9 March 2012

**MAJOR PROJECT- MP06\_0101 MOD & MP11\_0093  
Pemulwuy Mixed Use Development, Redfern**

Jim Tsirimiagos  
Manager, Land Use and Planning  
RailCorp Property

| TITLE | Lawson Street Bridge Works                                                                                              | DATE    | June 2010    |

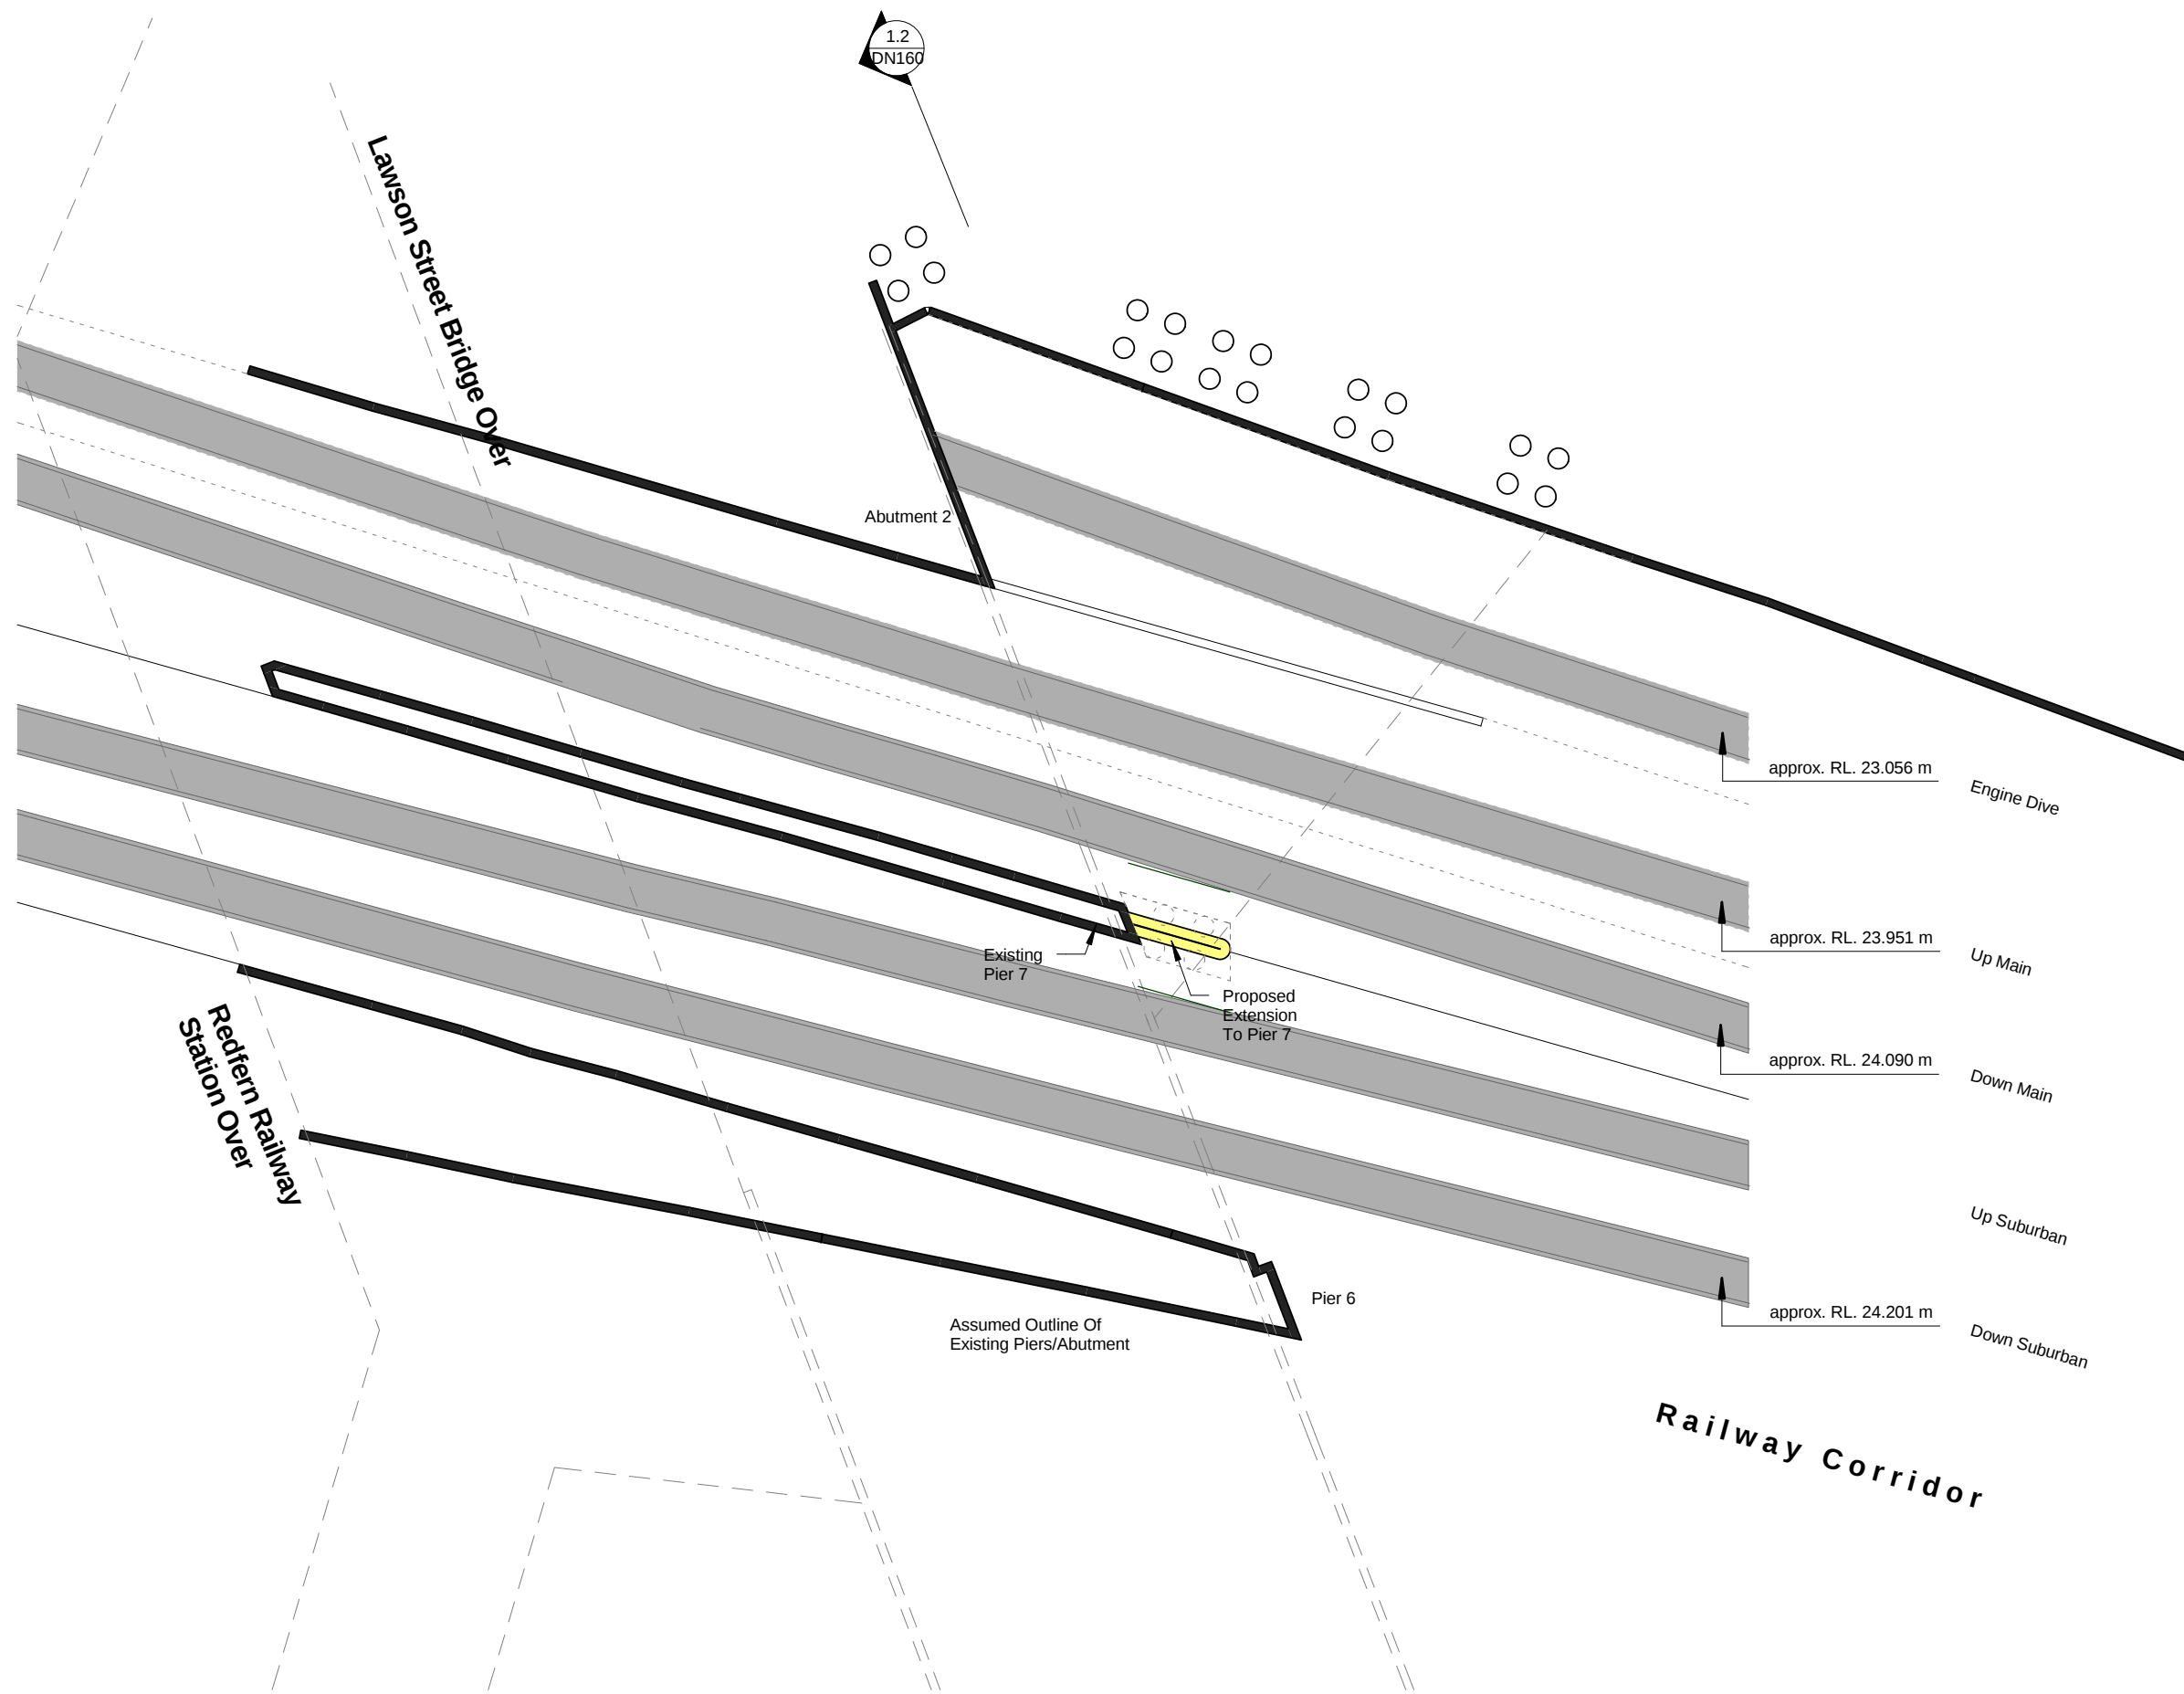
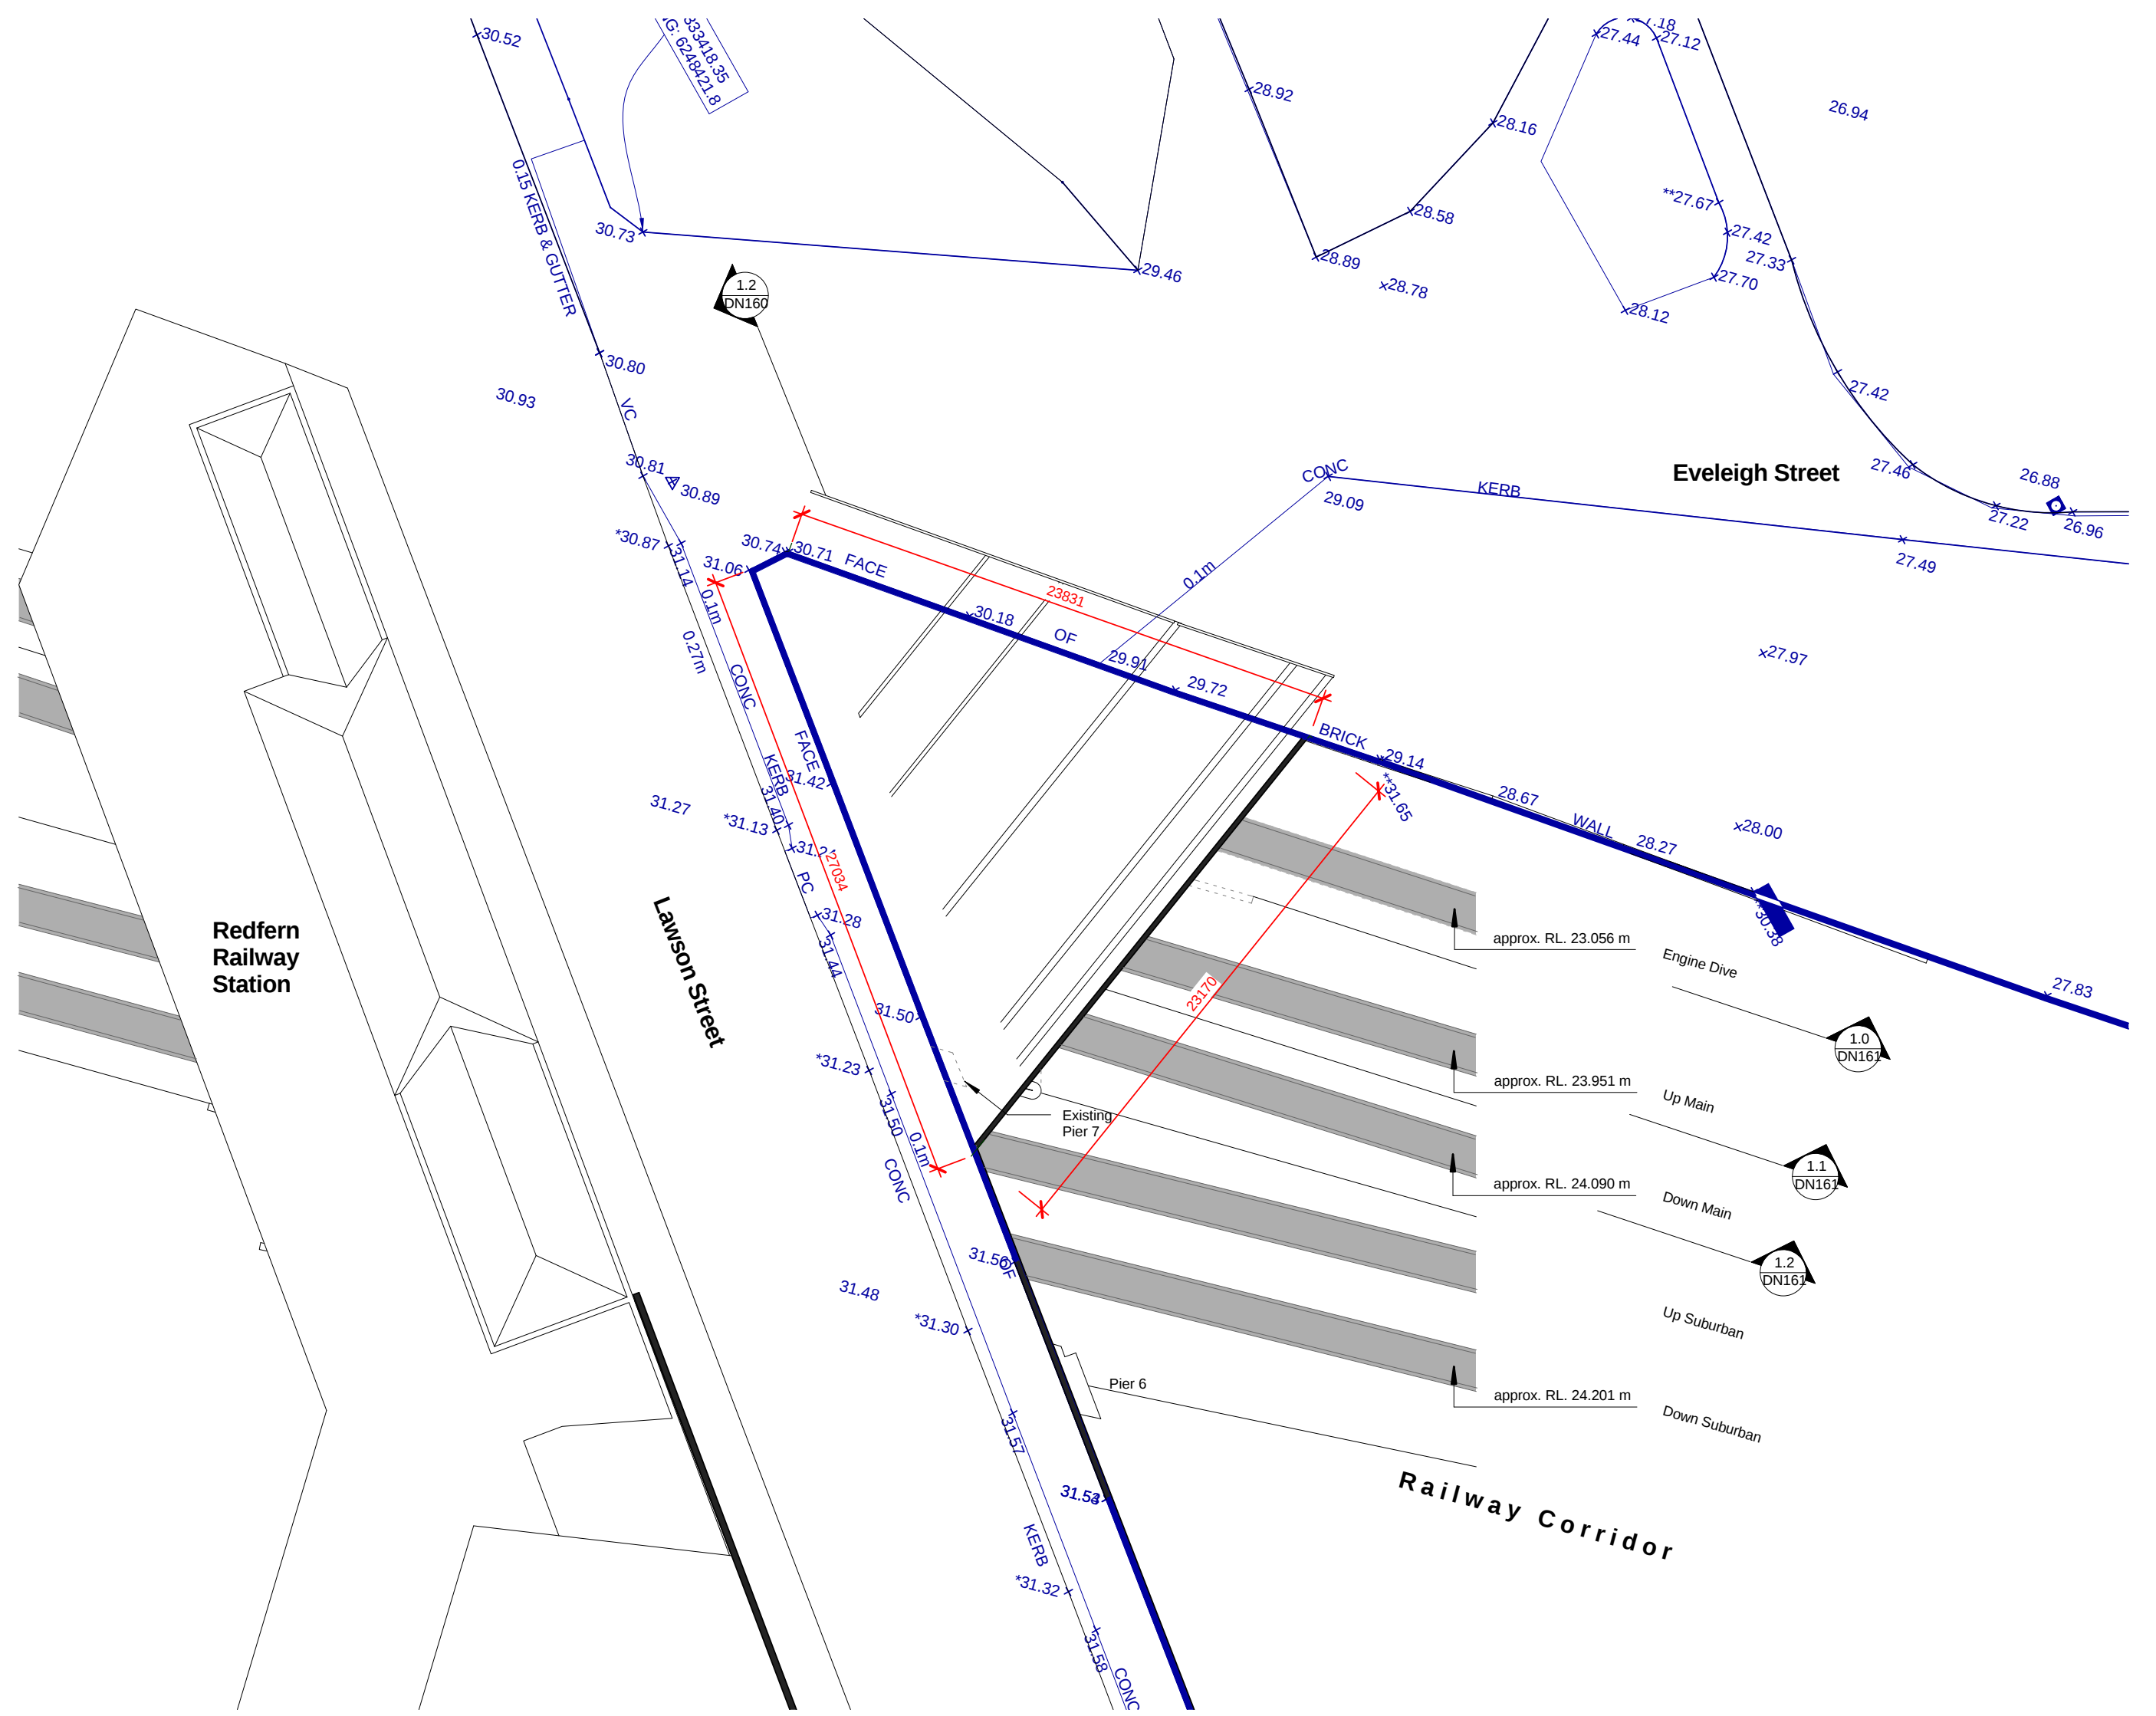
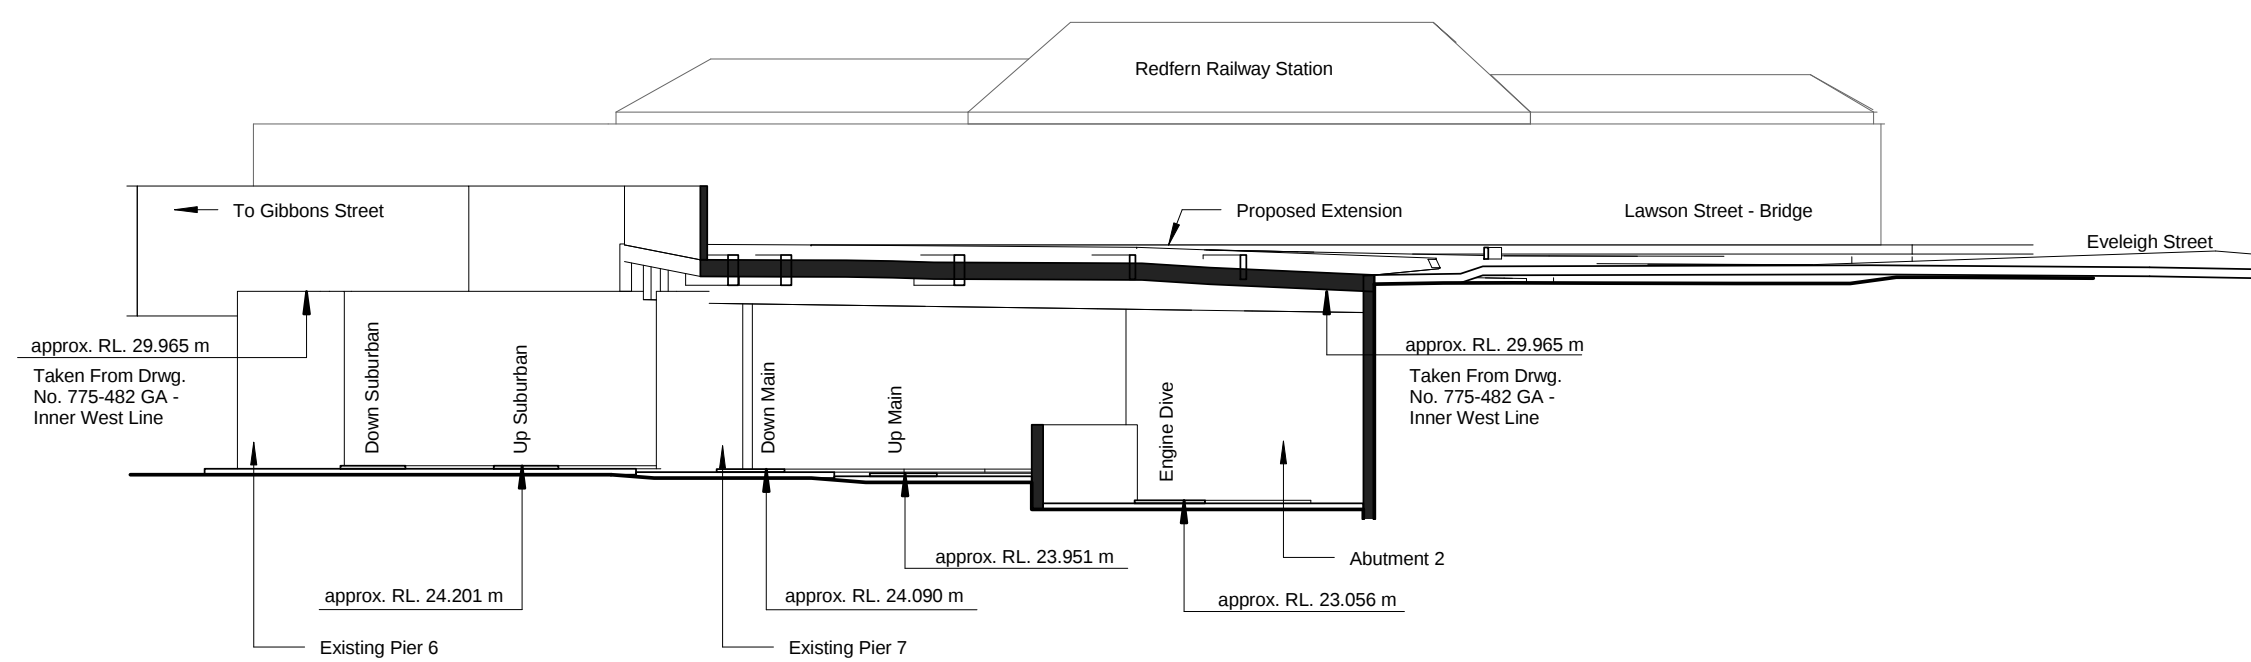
- *The overbridge is listed on the RailCorp Section 170 Register and State Heritage Register. If any changes are proposed, a Section 60 approval will be required (or minor works as an exemption).*

- *The assessment attributes 'moderate' significance to the overbridge, which is generally concur with as an element of the overall 'State' significance of Redfern Station. The structure has been altered previously, is in moderate condition, and is a 'representative' structure. It does however contribute to the existing setting of the station and the murals on this structure are noted as having social/aesthetic values - and as such its conservation should be sought as part of any proposal.*

- *The adjacent retaining walls and concrete block above are not currently on the Section 170 Register - but as the consultant notes they make the edge of the City of Sydney conservation area. The concrete block walls would appear to contribute to aesthetic/social values of place. In relation to the assessment regarding the side brick retaining wall - there are kms of this across the network, and the consultant provides no clear justification as to why this section is more significant than any other retaining wall of the period - and attributes no level of significance to it (State/Local) - only 'high' which is a methodology not used by the NSW Heritage Branch.*

- *The consultant assesses the concrete block walls as follows:  
'The murals painted on the Eveleigh Street concrete block wall and the Lawson Street Overbridge north wall were painted by the Aboriginal community as a marker to signify the entrance to The Block, an area of considerable significance to the Aboriginal people and local community. The AHC has stated the murals would be retained.'*

*However, the consultant then concludes that these parts of the wall could be removed. This issue needs further consideration or clarification.*
